SWS-SUSXW-S106-009768

04/05/2017

Application to Connect to the Public Sewerage System - Section 106 Water Industry Act 1991. Location: 52-56 Ferring Street, Ferring, Worthing, West Sussex, BN12 5JP.

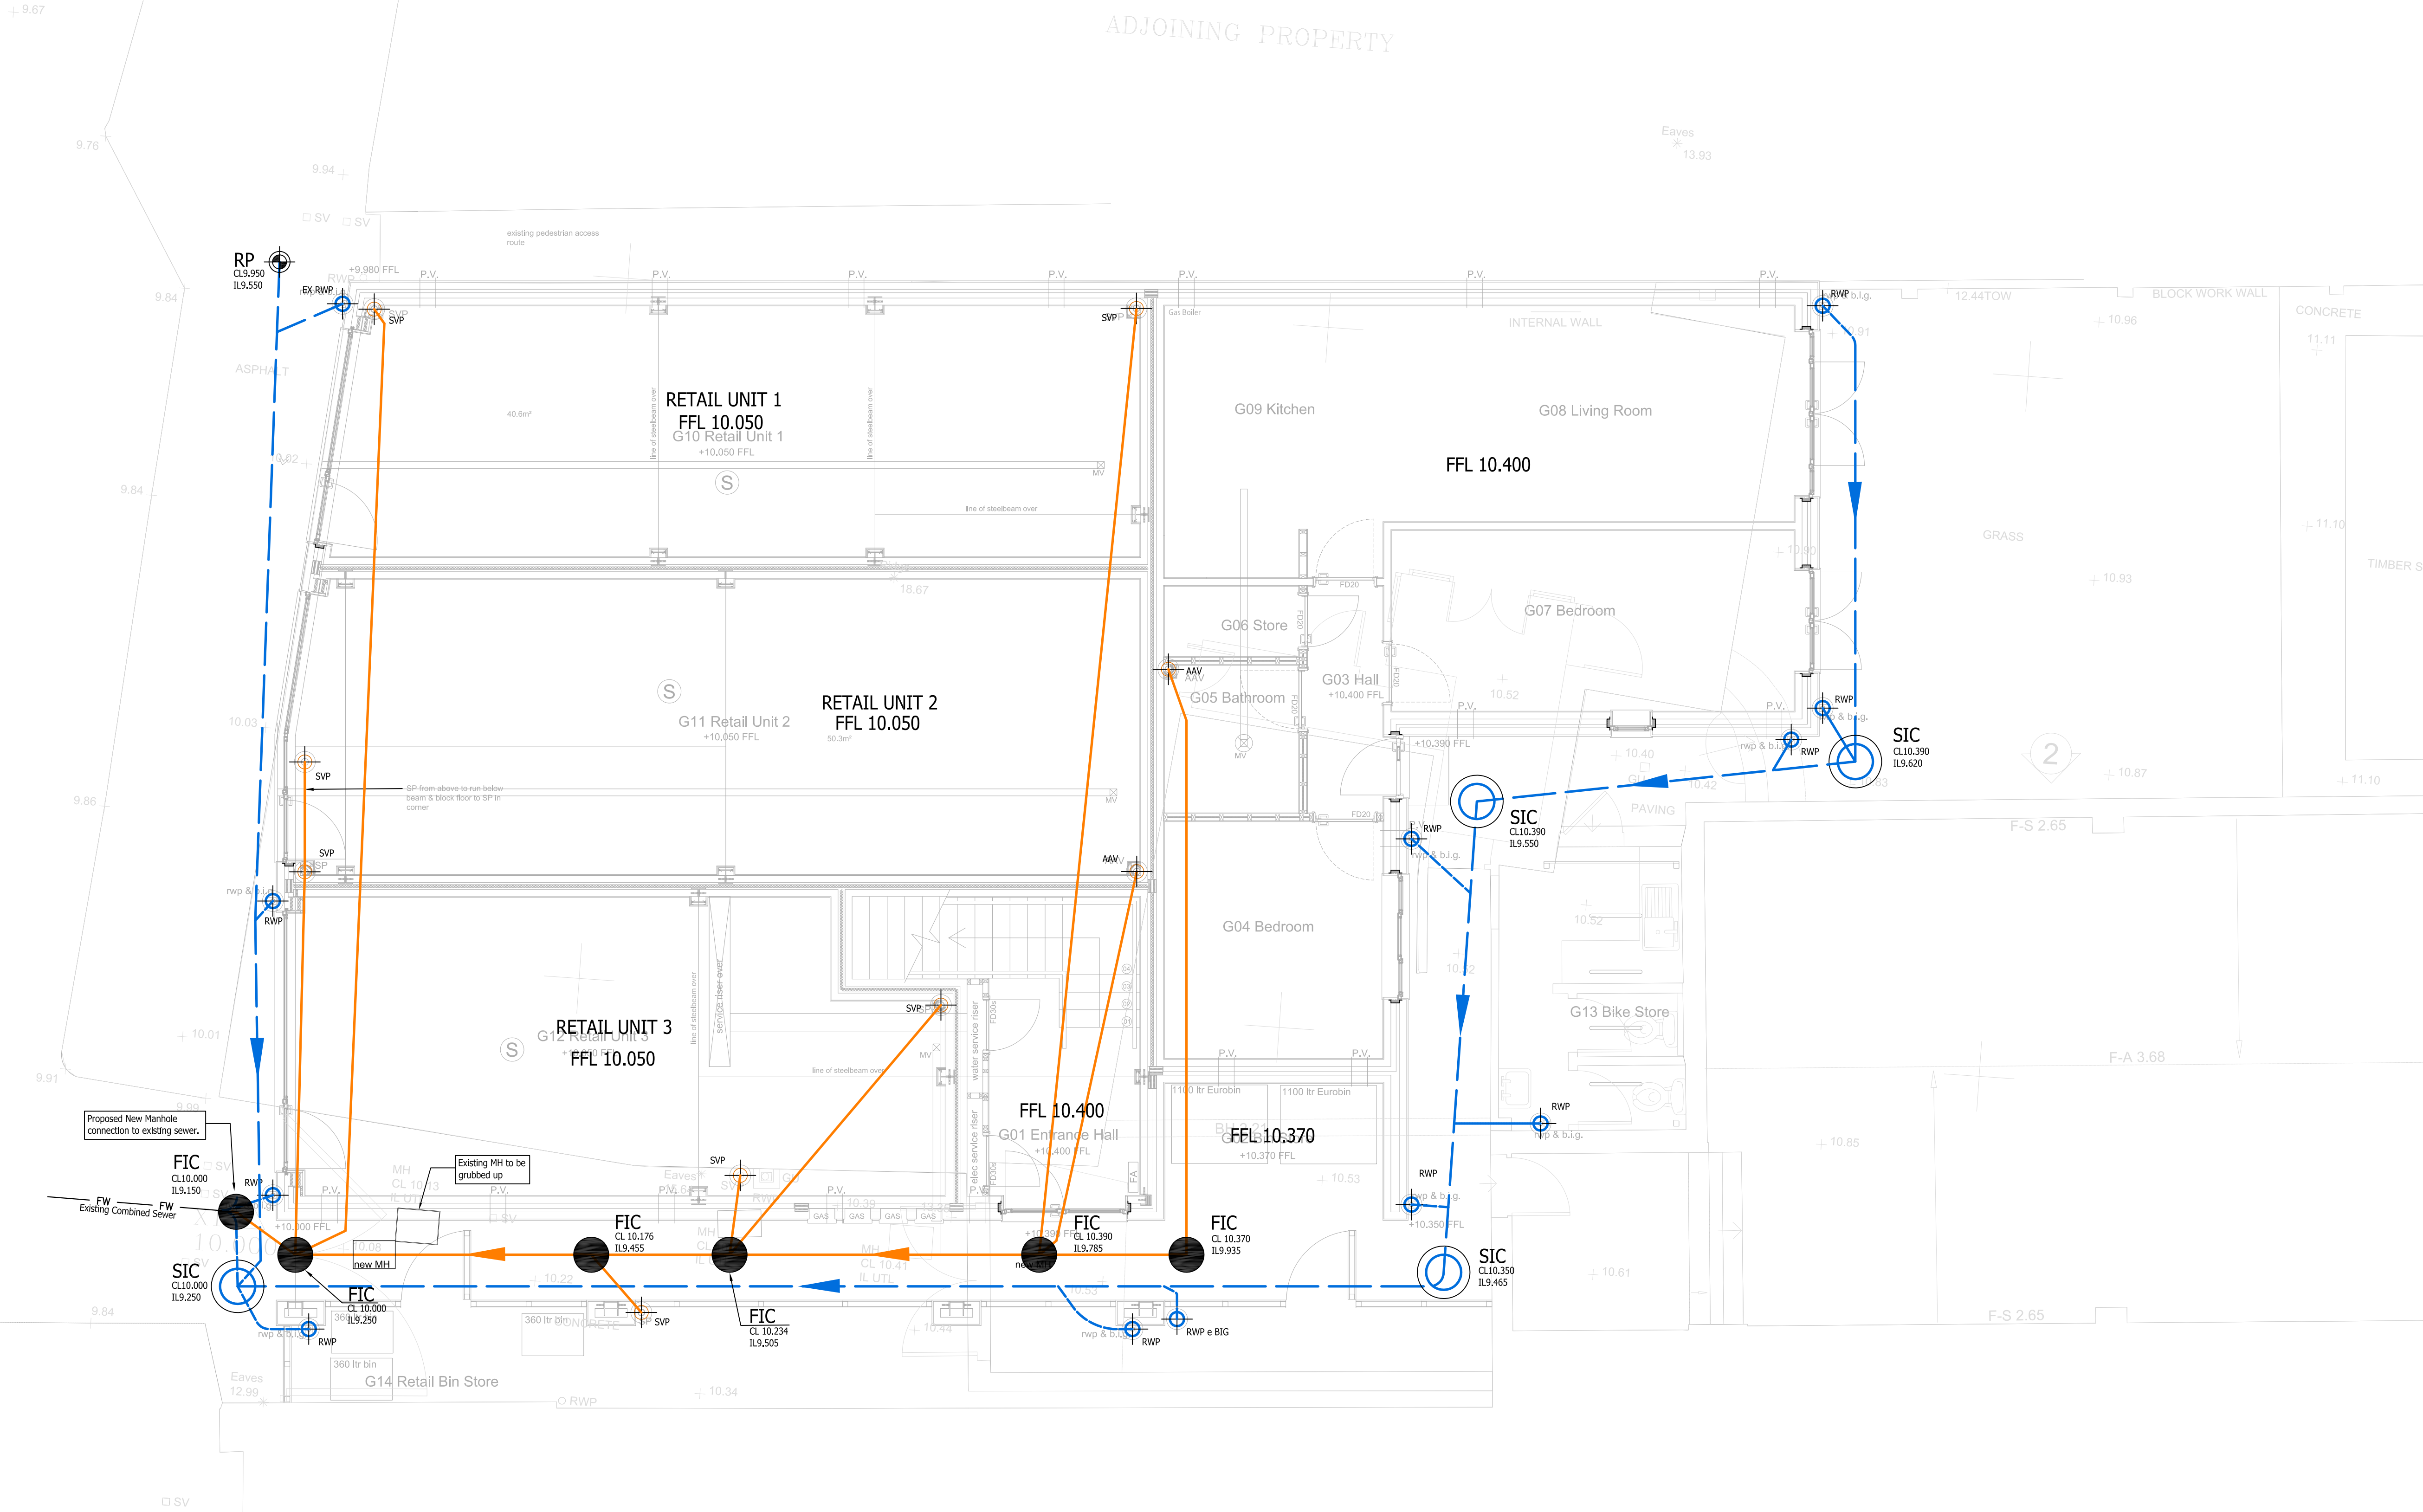
Further to your recent application to connect to the public sewerage system at the above location, I am pleased to inform you that your proposal to connecting combined flows to the foul sewers via existing lateral has been approved subject to the following provision: -

Connections to existing manholes and arrangement of pipe junctions within the manhole should be in accordance with Sewers for Adoption 7th edition and Southern Water guidance documentation.
